DECISION DELEGATED TO HEAD OF PLANNING

Application No: H06-0299-24 **Applicant:** Mr O Read

Proposal: Details of landscaping & tree planting, site & floor levels, contamination of land or pollution of controlled waters, boundary treatments, foul and surface water disposal (Conditions 4, 5, 6, 11 & 15 of H06-0848-23)

Location: Land Adjacent To Sea Breeze Marsh Road Gedney Drove End

JOB NO.	PAPER SIZE	DATE
6797/C02	A1	MAR 2024

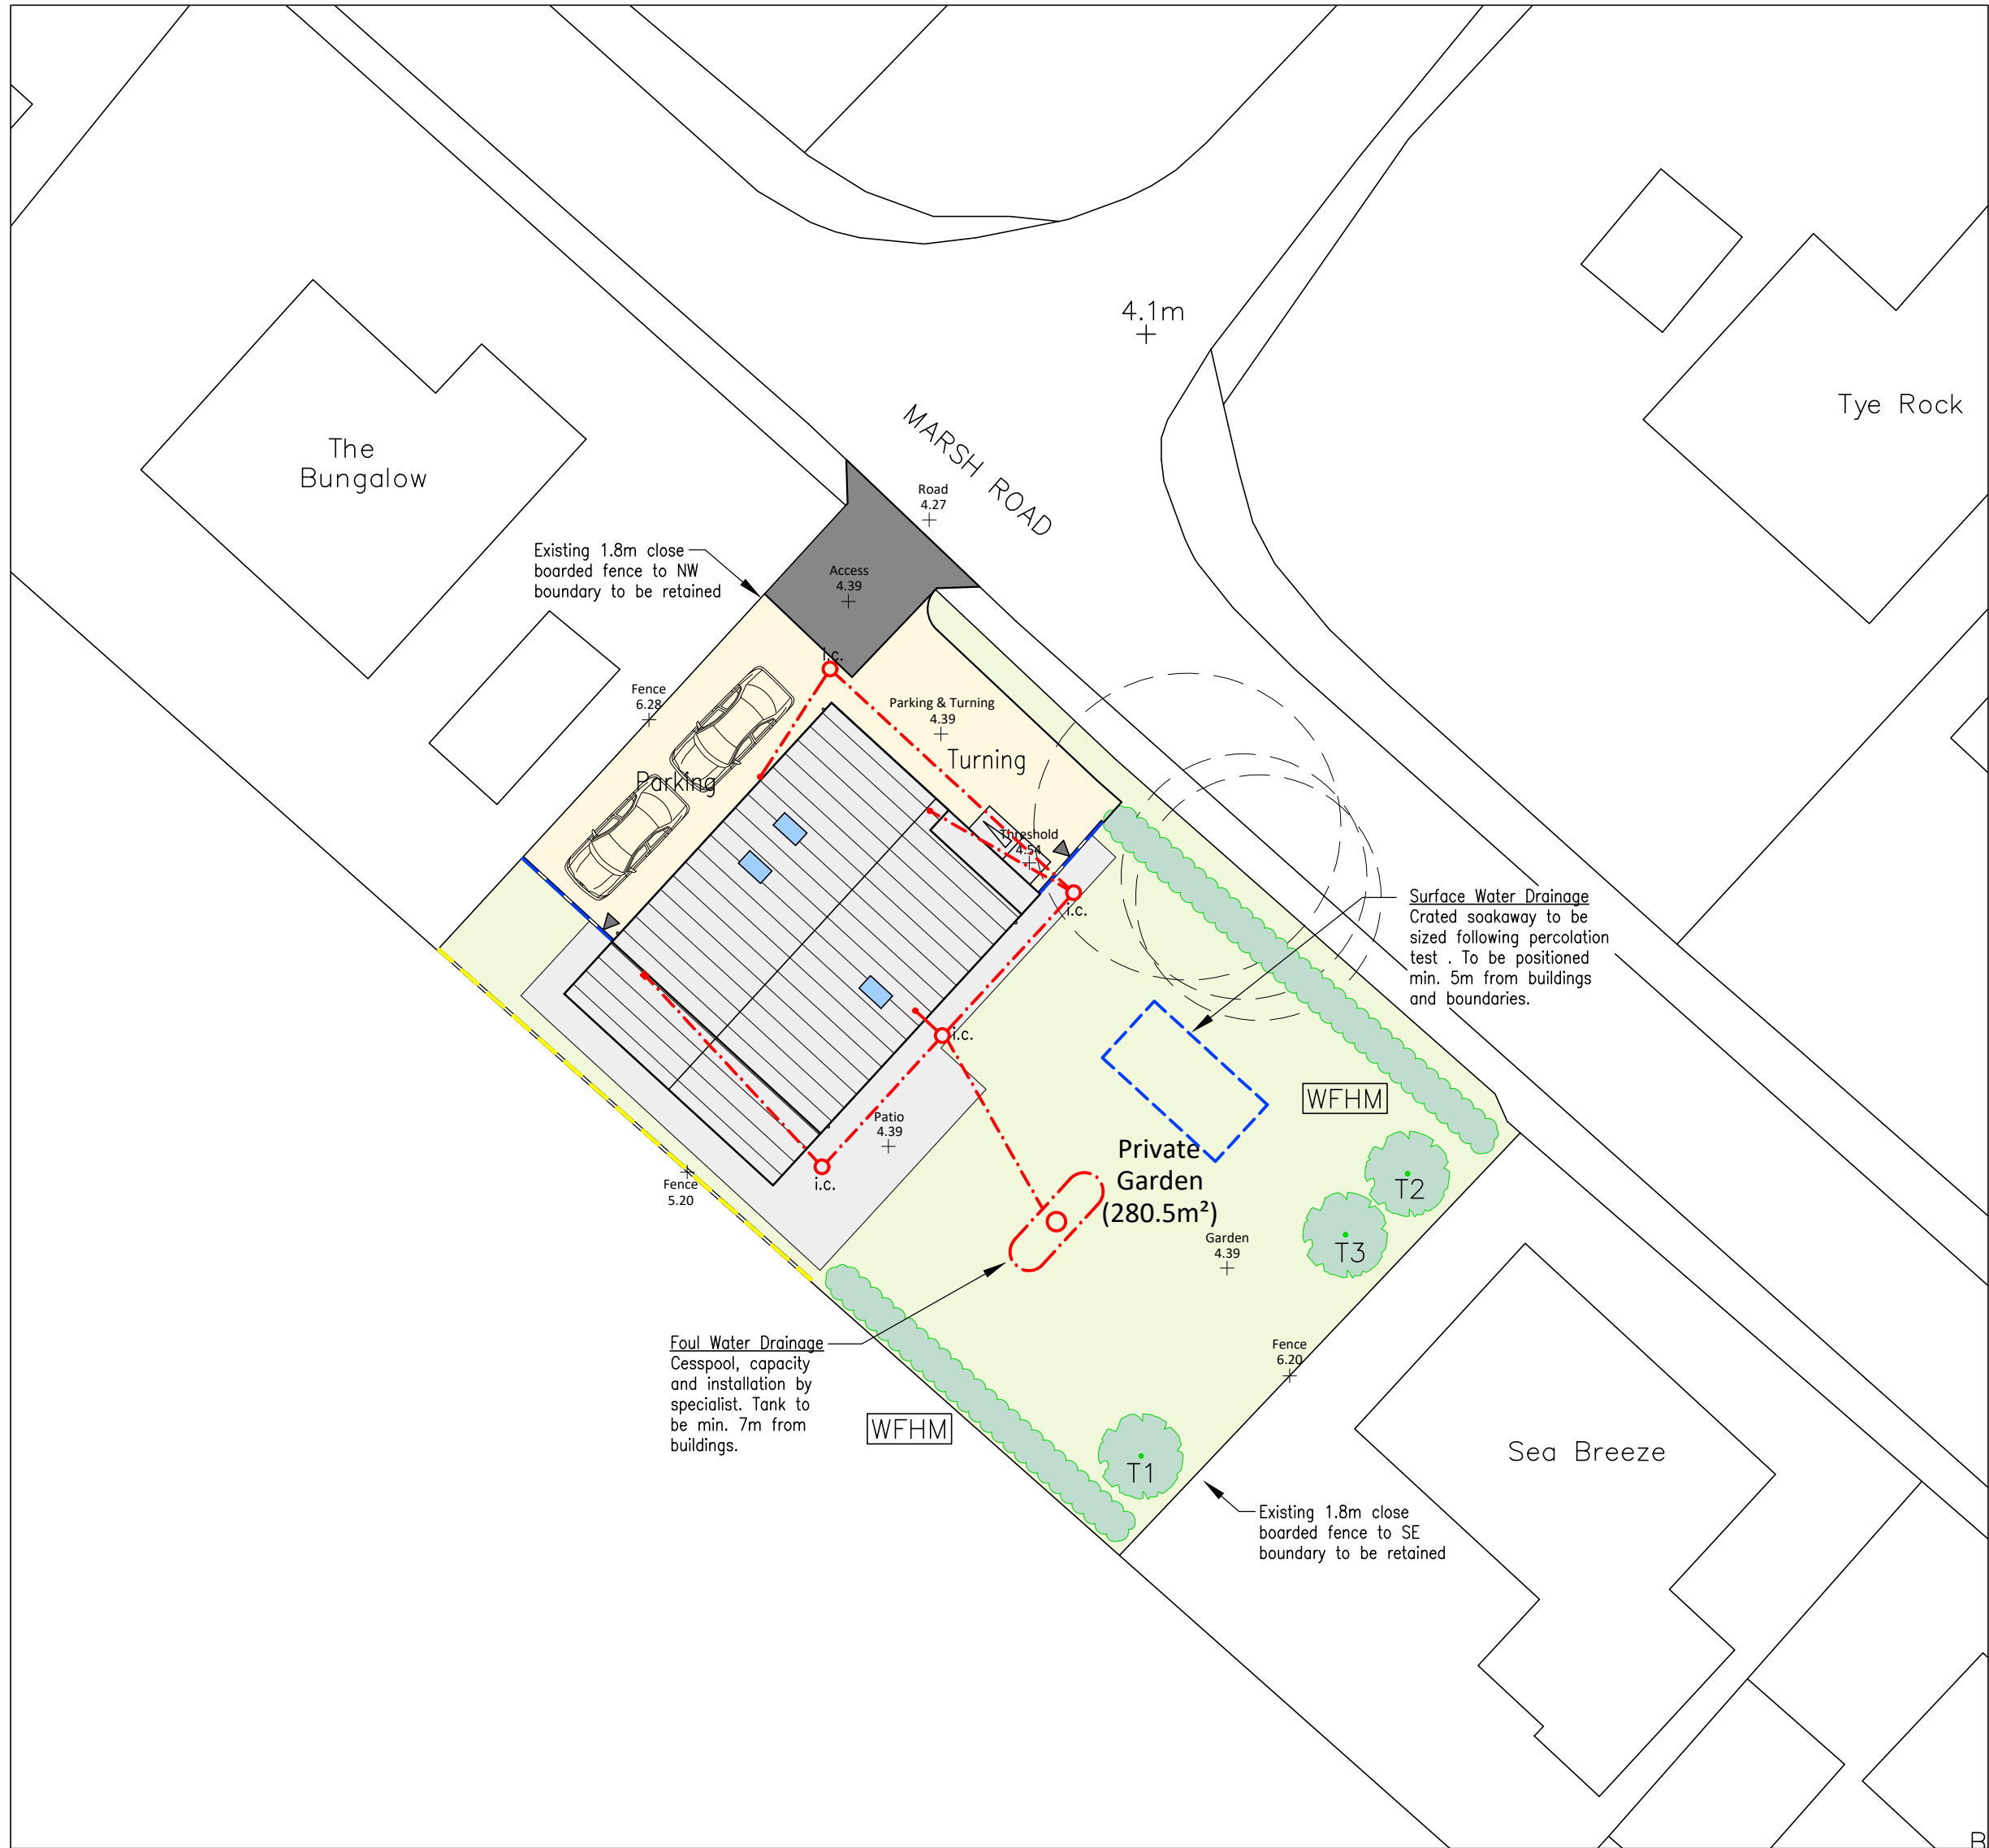
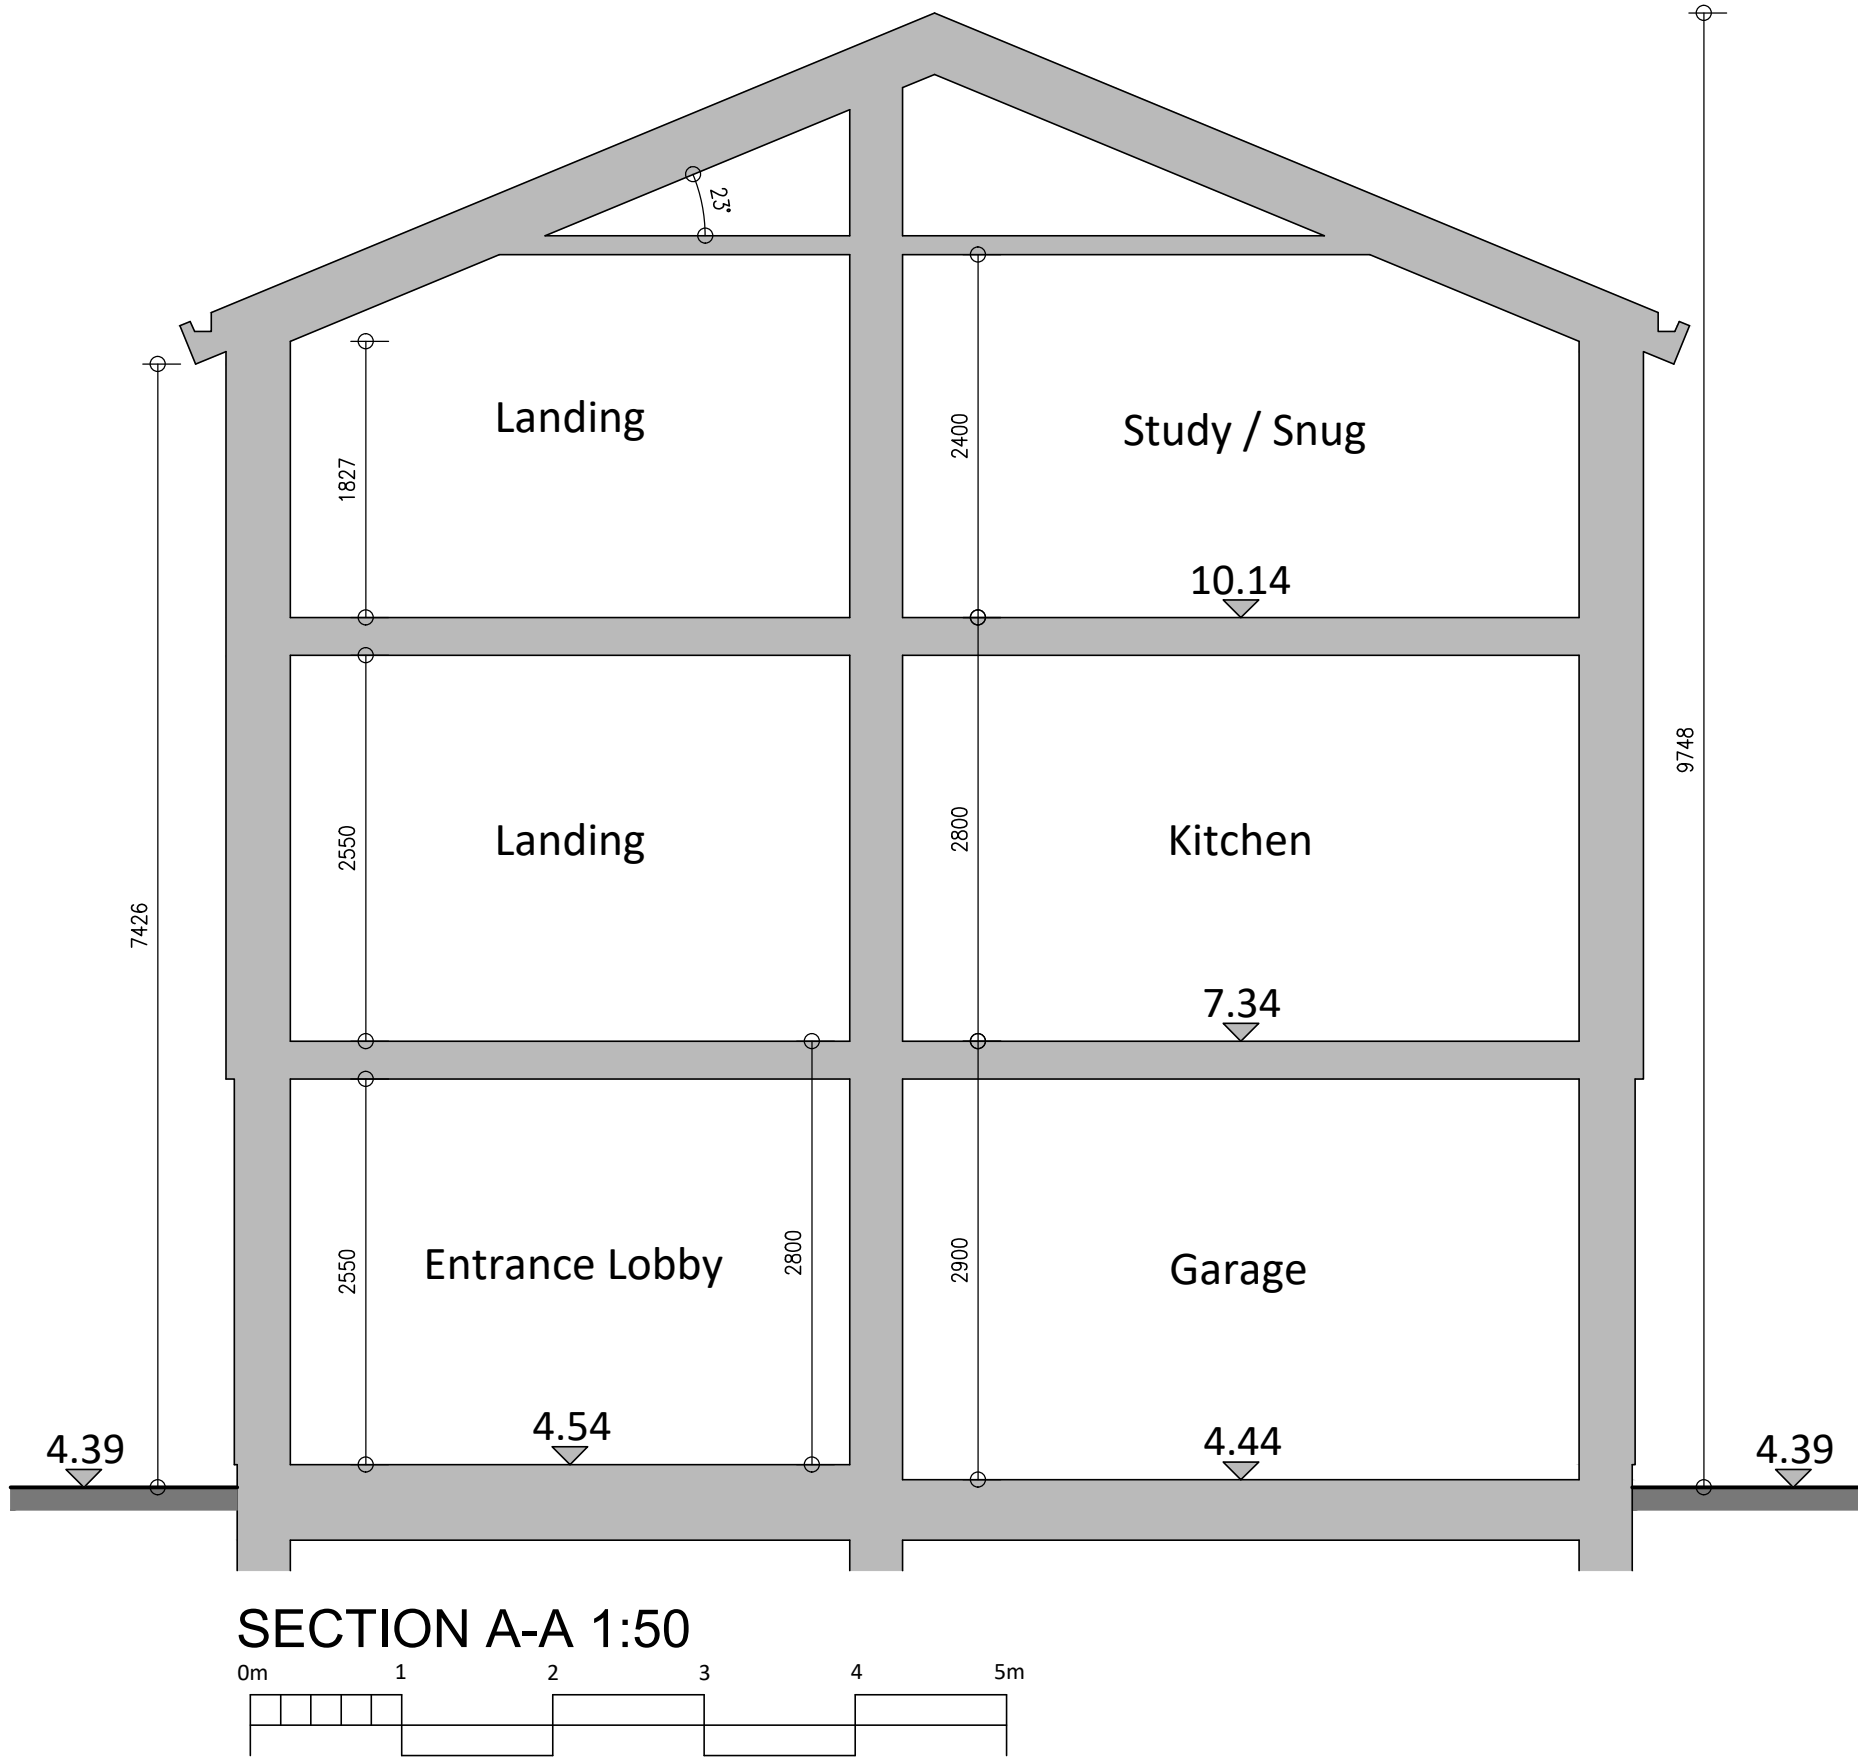
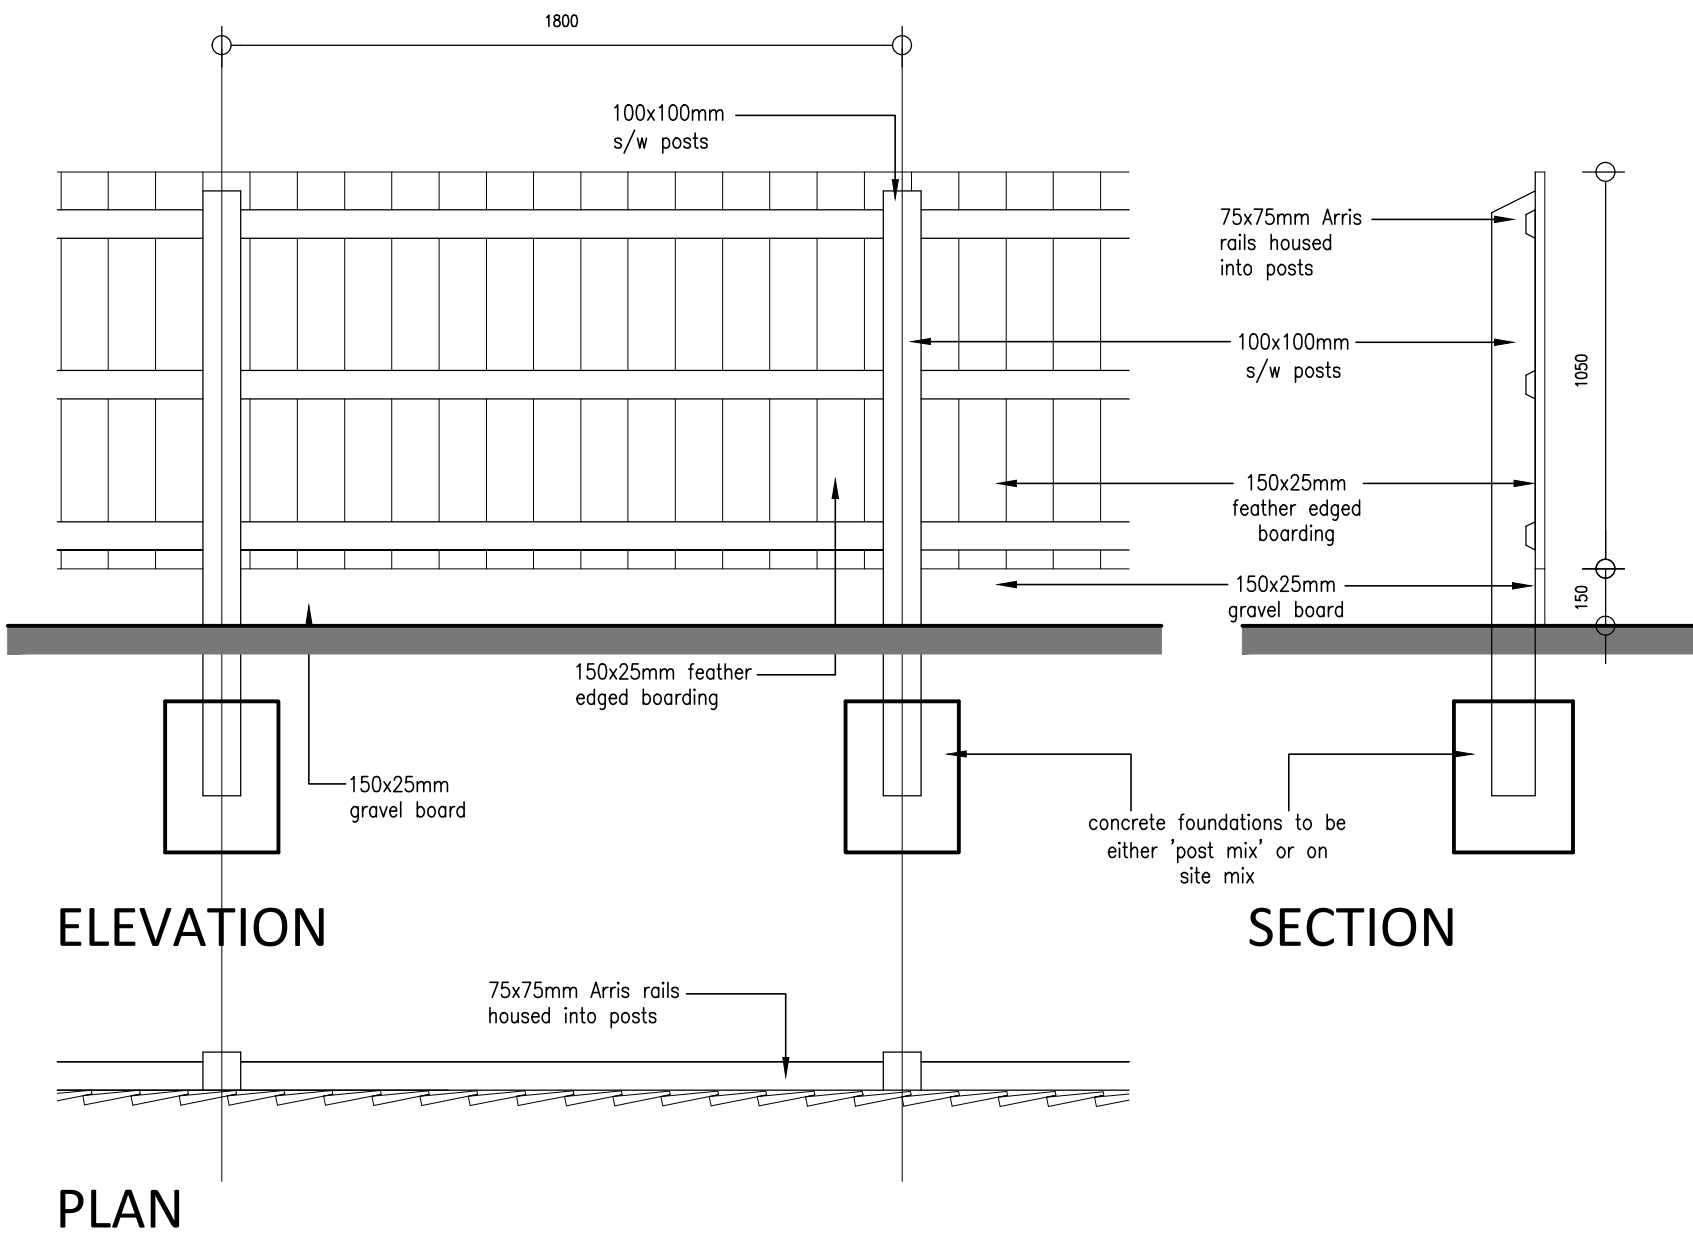
From the plan labelled '6797/C02' it shows there are two fence designs and a separate gate. On both side elevations there is a 1.8m close boarded fence with a 1.2m close boarded fence running across the north western elevation of the rear curtilage. Directly adjacent to the rear fence there shall be a hedge connecting to the side fence, furthermore directly opposite this there shall also be a hedge being of a similar length. These boundary treatments are considered to provide adequate privacy for the residents of this property once constructed as well as providing cover for neighbouring plots. There shall be no overshadowing or overbearing issues either.

South Holland Internal Drainage Board were consulted on this application, through this process they raised no objections. Consent may be required under Byelaw 3, it is not currently required for Section 23 and is not applicable to Byelaw 10. From 6797/C02 it shows that there is a crated soakaway within the private garden for surface water drainage, it is to be positioned a minimum of 5m from buildings and boundaries. Furthermore, there shall be a cesspool below this for foul water drainage with the tank to be a minimum of 7m from buildings.

Byelaw 3 (Surface Water) - The applicant has indicated that they intend to dispose of surface water via infiltration, however I cannot see that the viability of this proposal has been evidenced. We recommend that ground investigation is carried out to determine infiltration potential, followed by testing in line with BRE Digest 365 if onsite material is considered favourable for infiltration. If infiltration is not feasible at this site, following the drainage hierarchy we would expect the applicant to propose to discharge surface water to a watercourse. In this case, consent would be required under Byelaw 3. Please note that we recommend that any discharge is in line with the Non-Statutory technical standards for sustainable drainage systems (SuDS), therefore the Board is unlikely to grant consent for discharges in excess of greenfield rate. A surface water development contribution is likely to be payable as a condition of any consent granted under Byelaw 3 in line with the WMA's Development Control Charges and Fees.

Byelaw 3 (Treated Foul Water) - I note that the applicant intends to contain foul water using a cesspool, which would then be disposed of off-site. However, please be advised that should there be a discharge of treated foul water to a watercourse, consent would be required under Byelaw 3.

Condition 11 of H06-0848-23 can therefore be discharged.

Condition 15 of H06-848-23 can therefore be discharged.
